HELIOS RENEWABLE
ENERGY
PROJECT

PINS Document Number:
EN010140/APP/6.3.7.3

**Environmental Statement
Appendix 7.3:
Viewpoint Correspondence**

**Helios Renewable Energy Project – John Wainwright, Principal Landscape Architect NYCC
30/6/2022**

Drawing Title:
Viewpoint Plan

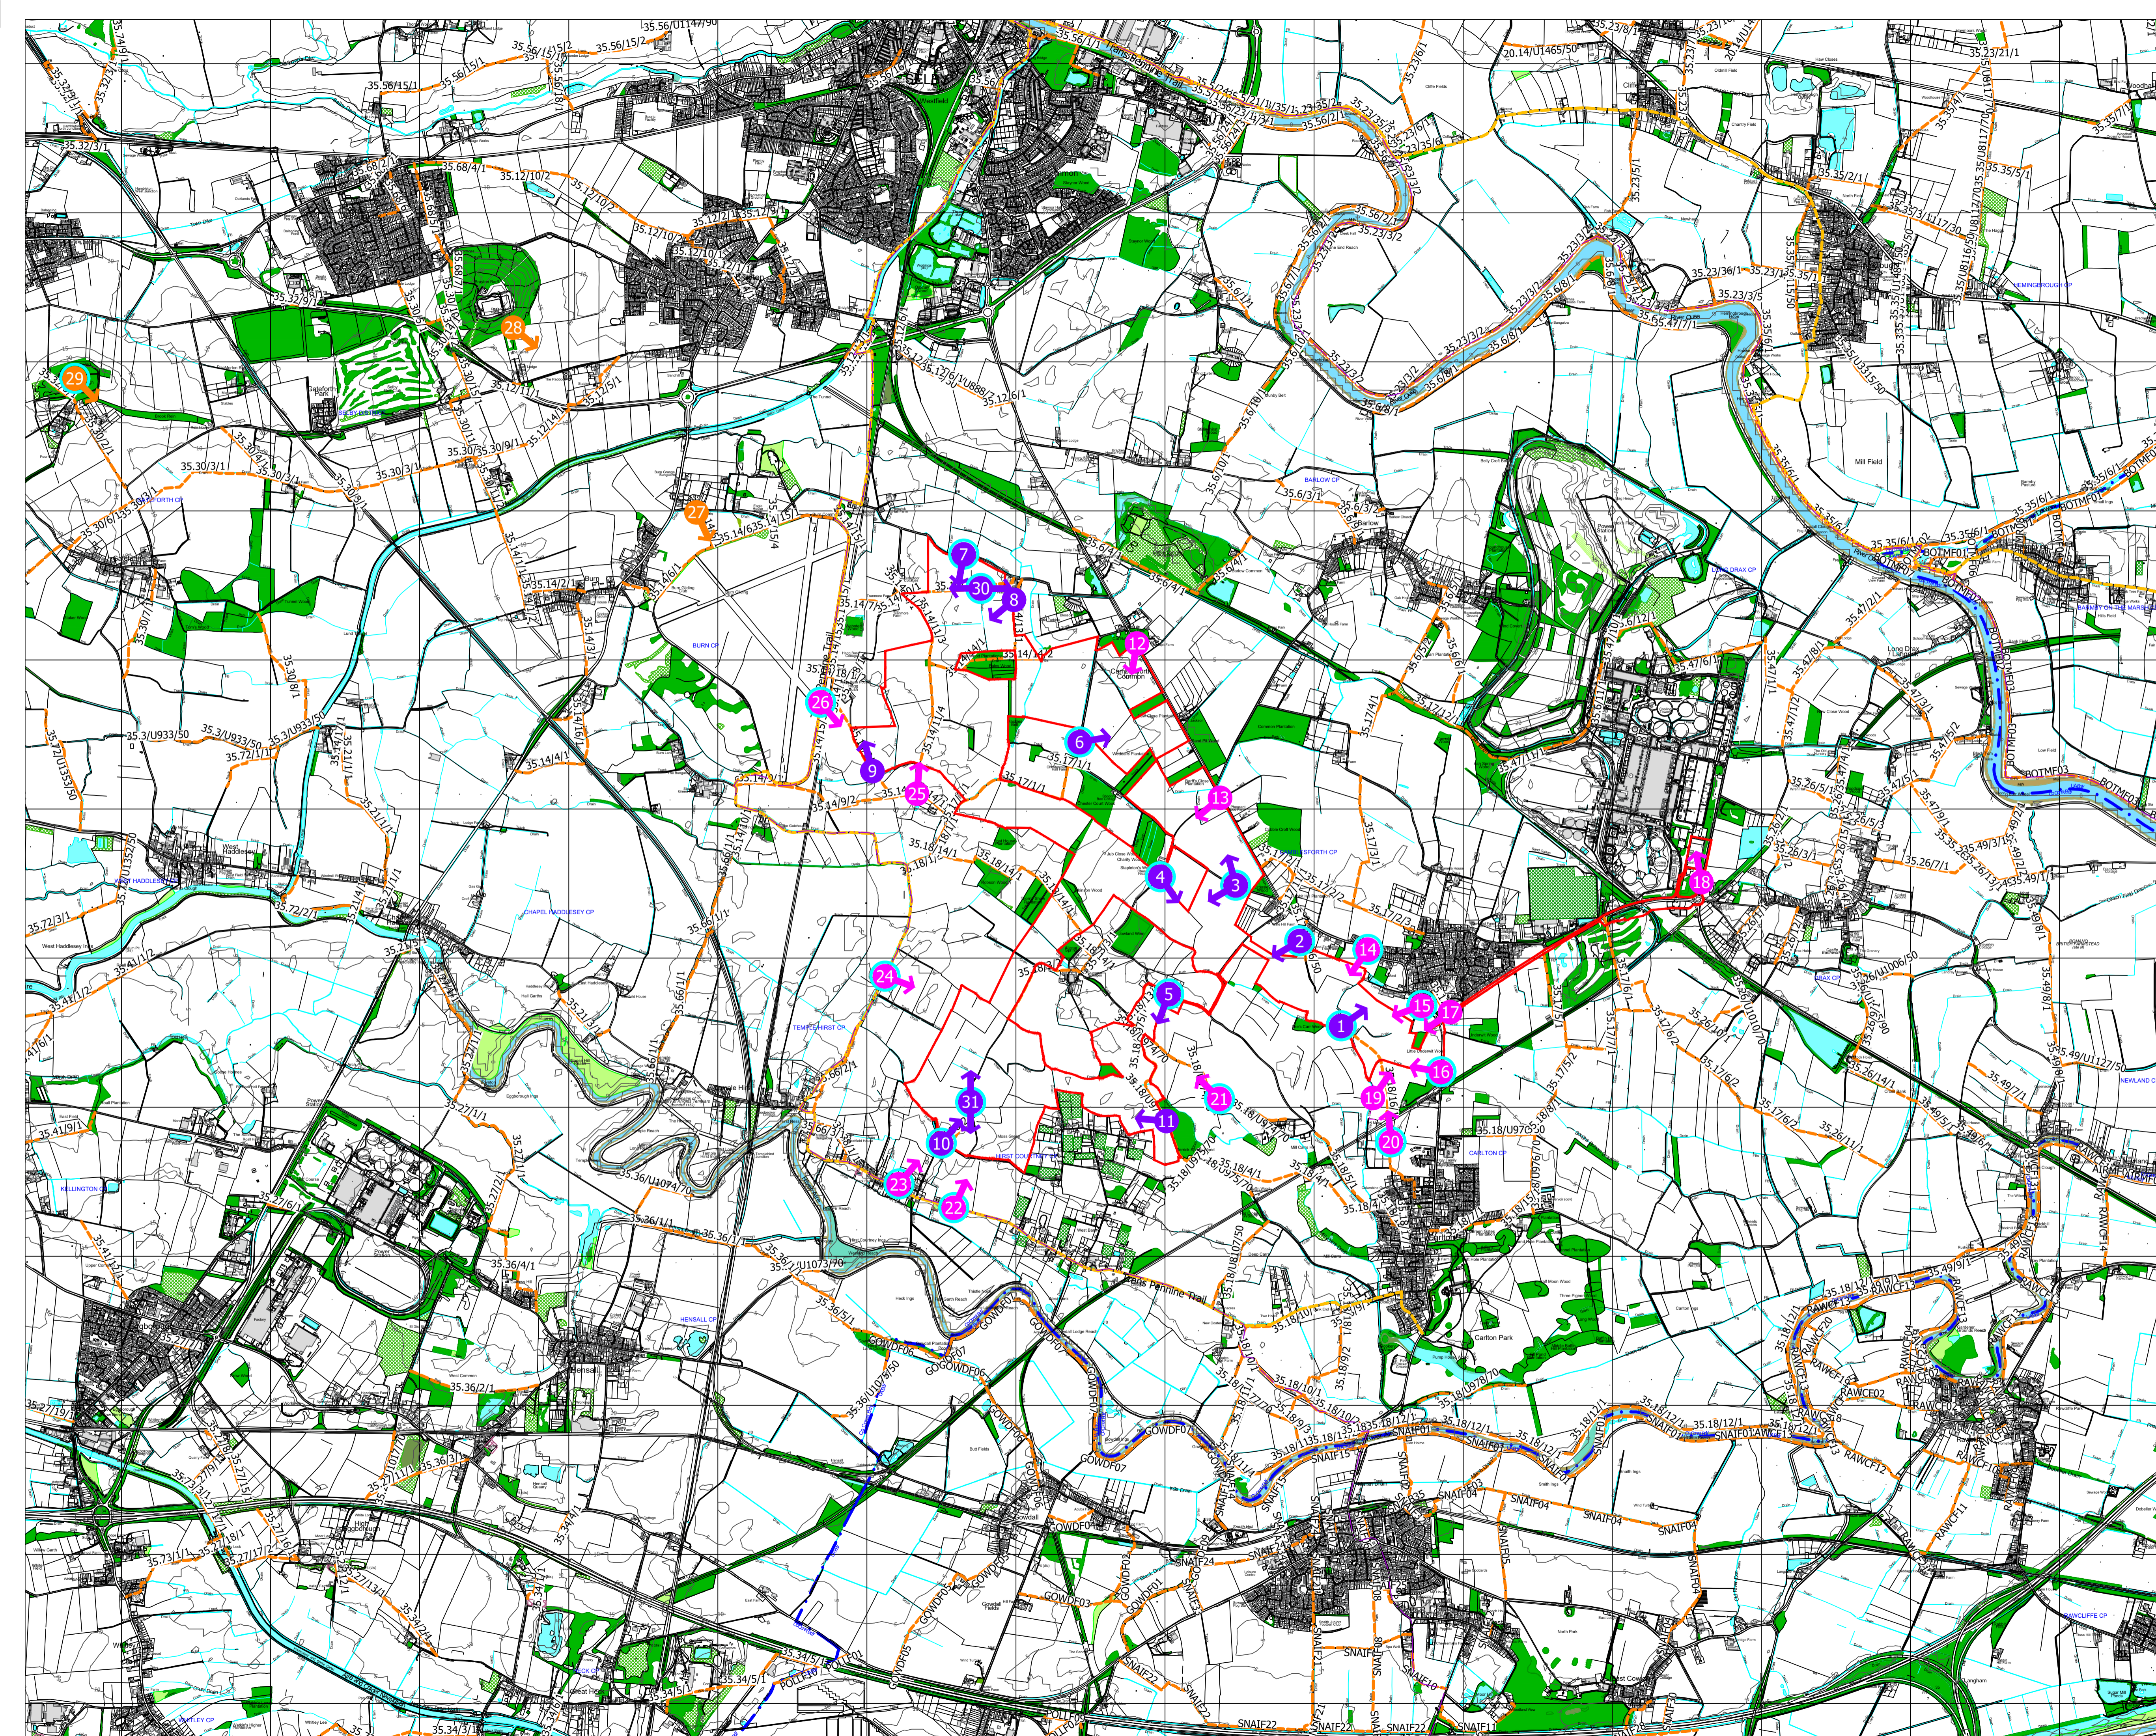
VP 02 - No. Needs relocating to show wider view / extents of the scheme closer to Crossley wood representative of nearby housing and road. **Adjusted location agreed PAN 63 and PAN 64**

VP 04 - Perhaps better located from Old Lane? Road & PROW ? **Adjusted location agreed Pan 188.**

VP 05 - Ok. Perhaps better located to show more extended views? **General location agreed, directed more to right to show openness as PAN 213.**

VP 07 - NO. Adjust location, show extents of scheme, not from behind a hedgerow. **General location agreed, directed more to right to show openness and context of access as PAN 227.**

VP 09 - No. Not sure why this has been located. General wider context? Not directly towards scheme? Move SE to Bull Alley Ln? **General location agreed, suggest directed more to right to show edge of track for context and openness towards scheme as PAN 055.**

- VP 10 - ? Question if better direction towards Scheme. **General location agreed, ensure directed towards scheme**
- VP 11- OK
- VP 12 - OK
- VP 13 - OK

- VP 14 - OK
- VP 15 – OK View of access point? **General location agreed as view of access point from highway.**
- VP 16 - OK
- VP 17 – OK wide context **Not representative of users within the site. Please ensure receptors stated are accurate in the assessment / Receptor Table.**

- VP 18 - OK
- VP 19 - No. Not sure what receptor represented? Is this located correctly on plan? **Location to be corrected. Please ensure views towards the proposed scheme.**

- VP 20 - OK **Recommend panning view slightly to the right or adjusted location. View partly obscured by a single building, which is not representative of the wider views along that section of the TPT, or views by passengers from the rail line.**

- VP 21 - OK
- VP 22 - NO. obscured by shed / undergrowth. Should be representative of views from nearby farm house or **Not particularly representative of vehicle travellers. Would be more useful in an adjusted location to represent residential views from nearby farm house.**

- VP 23 - OK
- VP 24 - OK
- VP 25 - No. Needs relocating to show extents of scheme representative of housing / road / PROW? Hardenshaw Lane? **Proposed view not useful and does not show extents of scheme, contrary to guidelines.**

- VP 26 - OK
- VP 27 - OK
- VP 28 - OK
- VP 29 - No. Needs relocating to show extents of scheme representative of views from Station Rd / A1041 **Current view not particularly useful or representative of views towards the scheme. Adjusted or additional location recommended from nearby junction A646 / A1041 directed southwards towards the scheme.**

VP 31 – No. Better as representative view from housing nr Barff View. Recommend directed more to left towards the scheme PAN 243 or adjusting location towards the edge of Burn village where there are open views towards the scheme.

VP 36 + 37 - No. Need relocating to show extents of the scheme. Take account of roadside hedgerows which could be cut. Recommend supplementing with additional photo of more open location directed towards the scheme.

Viewpoint	Notes
VP1	Retained
VP2	Adjusted to PAN 63 and PAN 64 as agreed
VP3	Retained
VP4	Adjusted to PAN 213 as agreed
VP5	Retained
VP6	Retained
VP7	Retained
VP8	Retained
VP9	Removed – revised site unlikely to be visible
VP10	Retained
VP11	Removed – revised site unlikely to be visible
VP12	Removed – revised site unlikely to be visible
VP13	Retained
VP14	Retained
VP15	Removed – no site access here
VP16	Retained
VP17	Removed – this part of site only proposed for underground cables
VP18	Retained
VP19	Retained
VP20	Retained
VP21	Retained
VP22	Removed. Site obscured by shed
VP23	Retained
VP24	Retained
VP25	Removed. Site not visible.
VP26	Retained
VP27	Retained
VP28	Retained
VP29	Retained
VP30	Removed – revised site unlikely to be visible
VP31	Retained
VP32	Retained
VP33	Retained
VP34	Removed – revised site unlikely to be visible
VP35	Removed – revised site unlikely to be visible
VP36	Removed – area removed from application
VP37	Removed – area removed from application

New VP A	View from PRow within site.
New VP B	Alternative view to VP 22 as suggested
New VP C	Alternative view to VP 25 as suggested
New VP D	View from New Road of proposed expansion of substation.
